DISTRICT COUNCIL
NORTH OXFORDSHIRE

Our Ref: 13/00321/OUT

Application under the Town and Country Planning Act 1990 for the following: OUTLINE - 1000 dwellings together with a local centre including retail (A1), financial services (A2), restaurants (A3-A5), up to a combined total floorspace of 1000m², employment space (B1) up to a total floorspace of 5000m² with the B1(a) office component limited to a maximum of 2,500m², associated car parking, a community primary school (including space for community uses (D1) and assembly and leisure uses (D2)), green infrastructure including formal and informal open space, amenity space, retained hedgerows, structural landscaping, supporting infrastructure (including gas, electricity, sewerage, water, telecommunications), sustainable urban drainage systems, new connection to the A361 Bloxham Road, pedestrian and cycling connections to the surrounding footpath and cycle network and any necessary demolition and ground remodelling

REQUIREMENTS UNDER REGULATION 22 (1) OF THE TOWN AND COUNTRY PLANNING (ENVIRONMENTAL IMPACT ASSESSMENT) REGULATIONS 2011 TO PROVIDE FURTHER INFORMATION IN RESPECT OF THE ENVIRONMENTAL STATEMENT

To produce a ZTV, the XYZ data of the viewpoint or object under analysis is required. XYZ data is the easting and northing point plus the height or Z co-ordinate of the subject above the ground level.

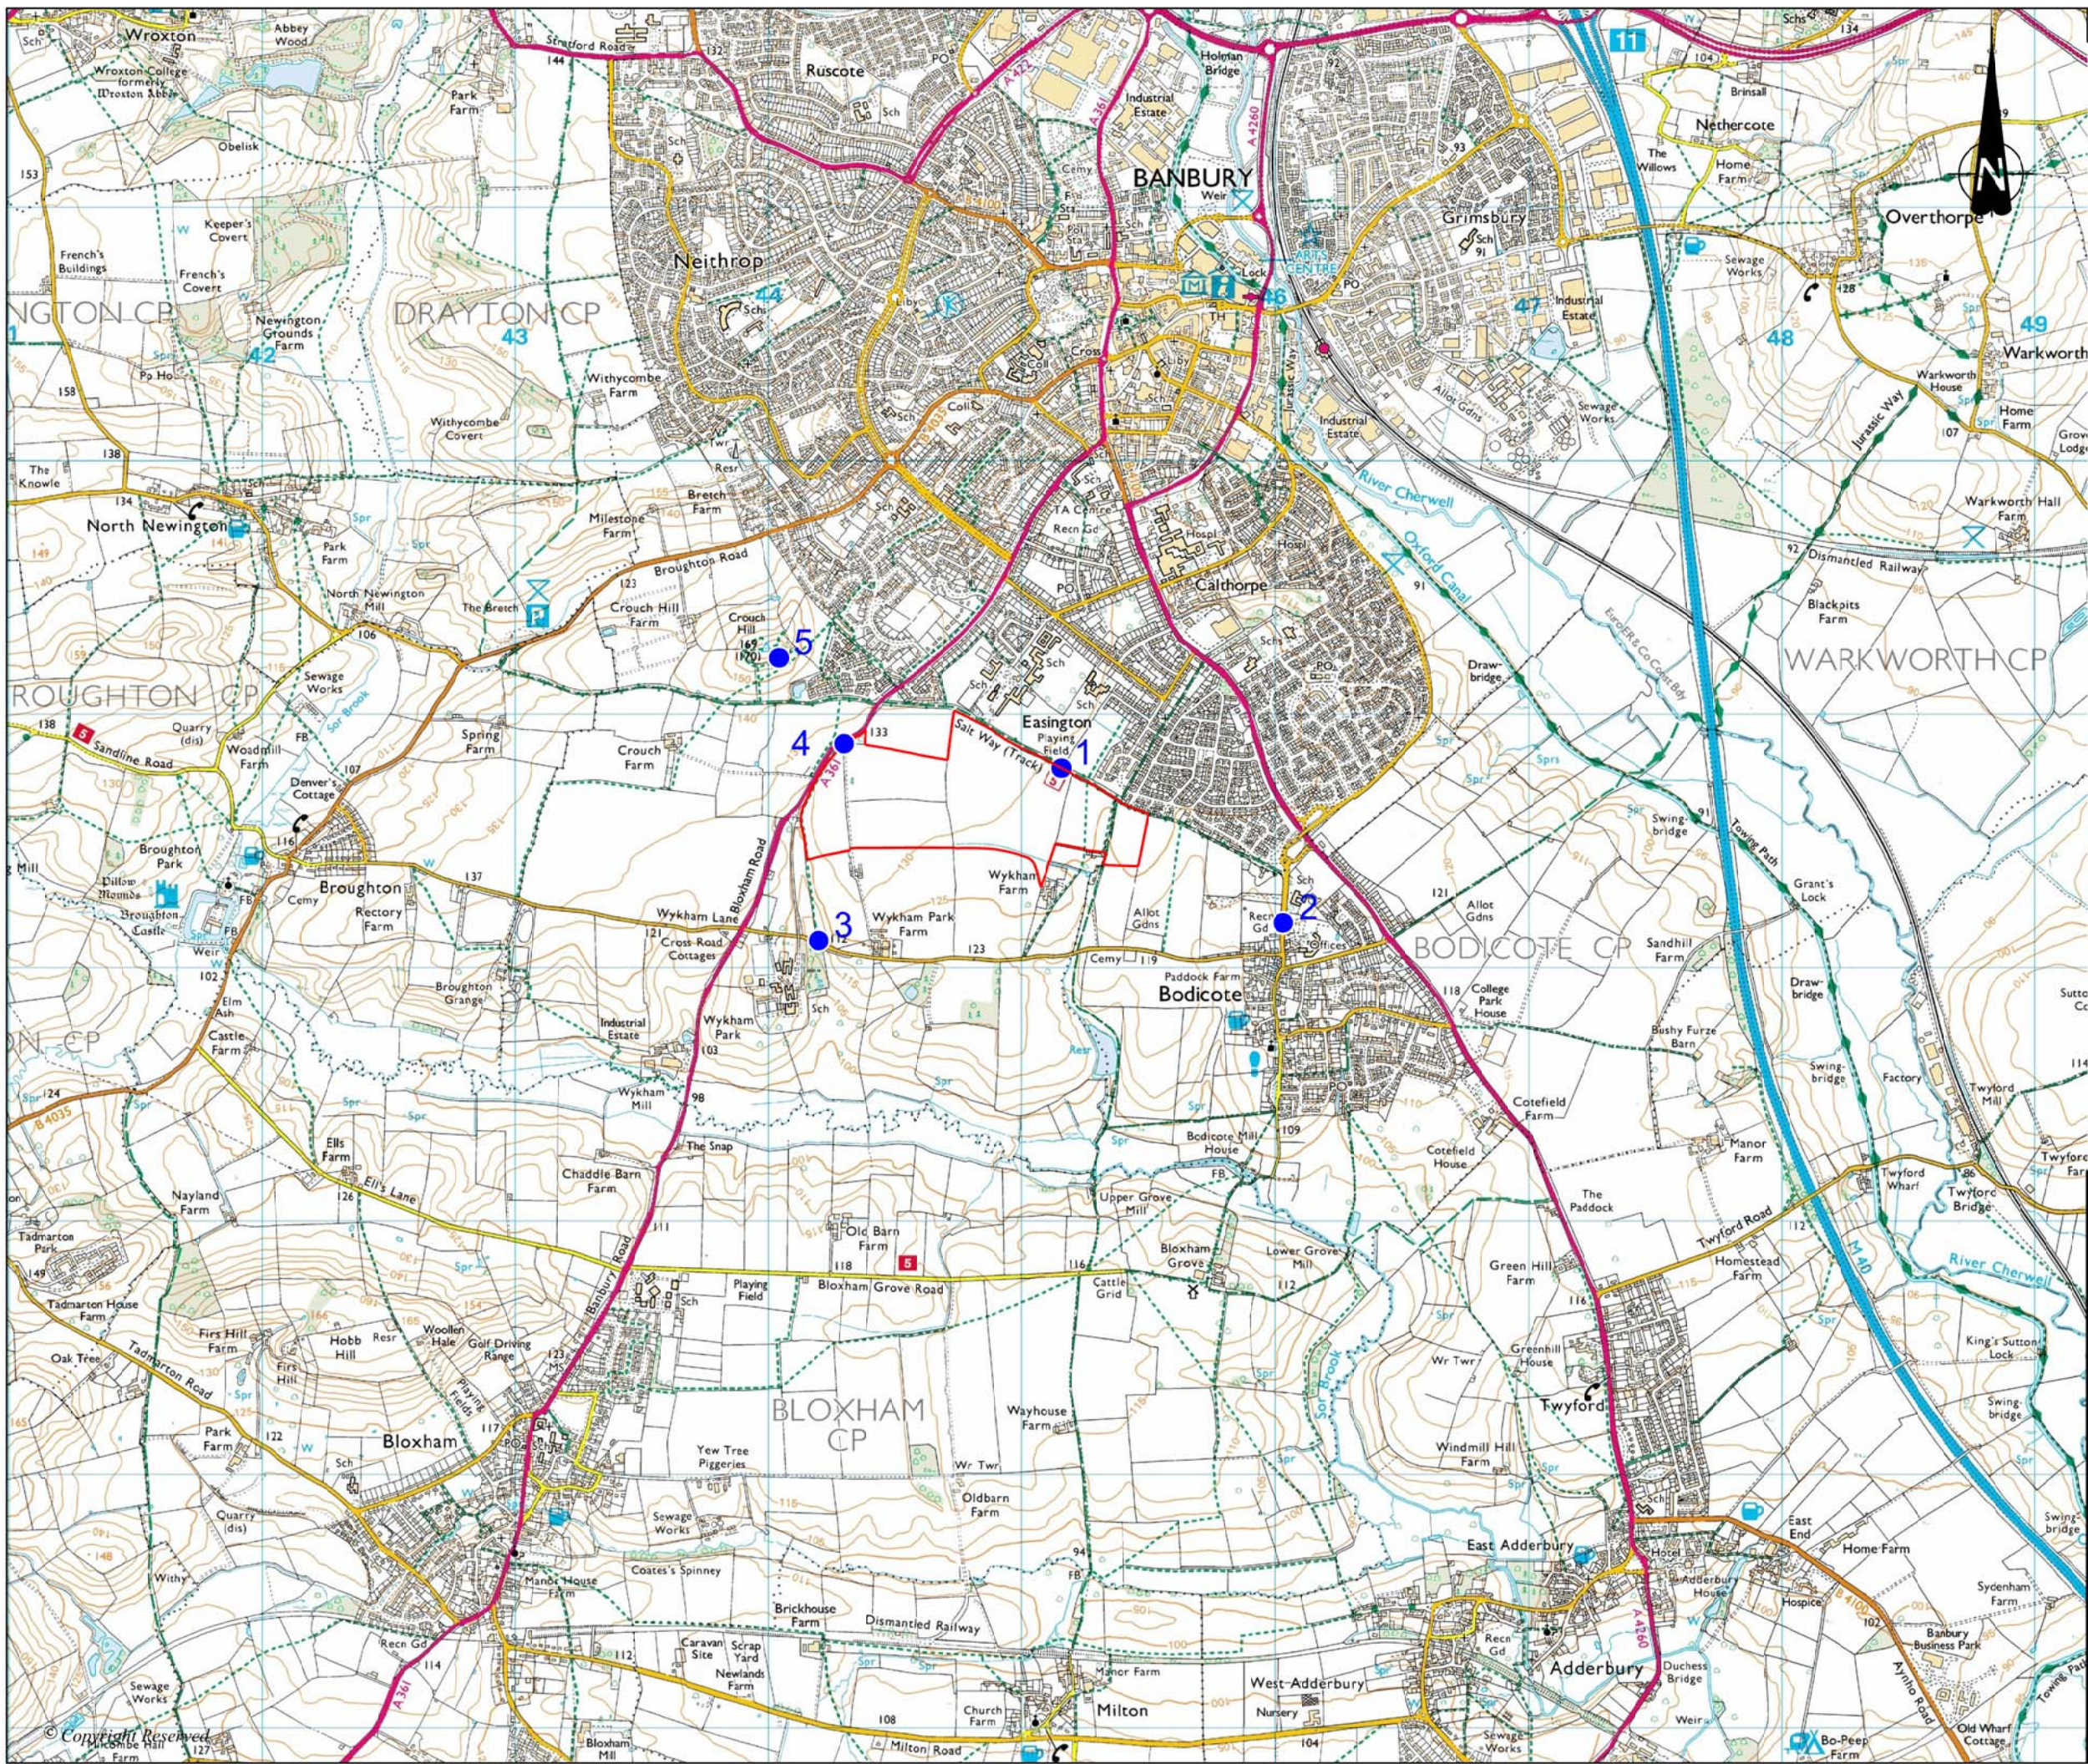
- 9.1.5. The Zone of Theoretical Visibility (ZTV) of the development has not been identified. The Council wishes to see this illustrated on a plan of a suitable scale. The ZTV should include a methodology and details of datasets used to create the ZTV.
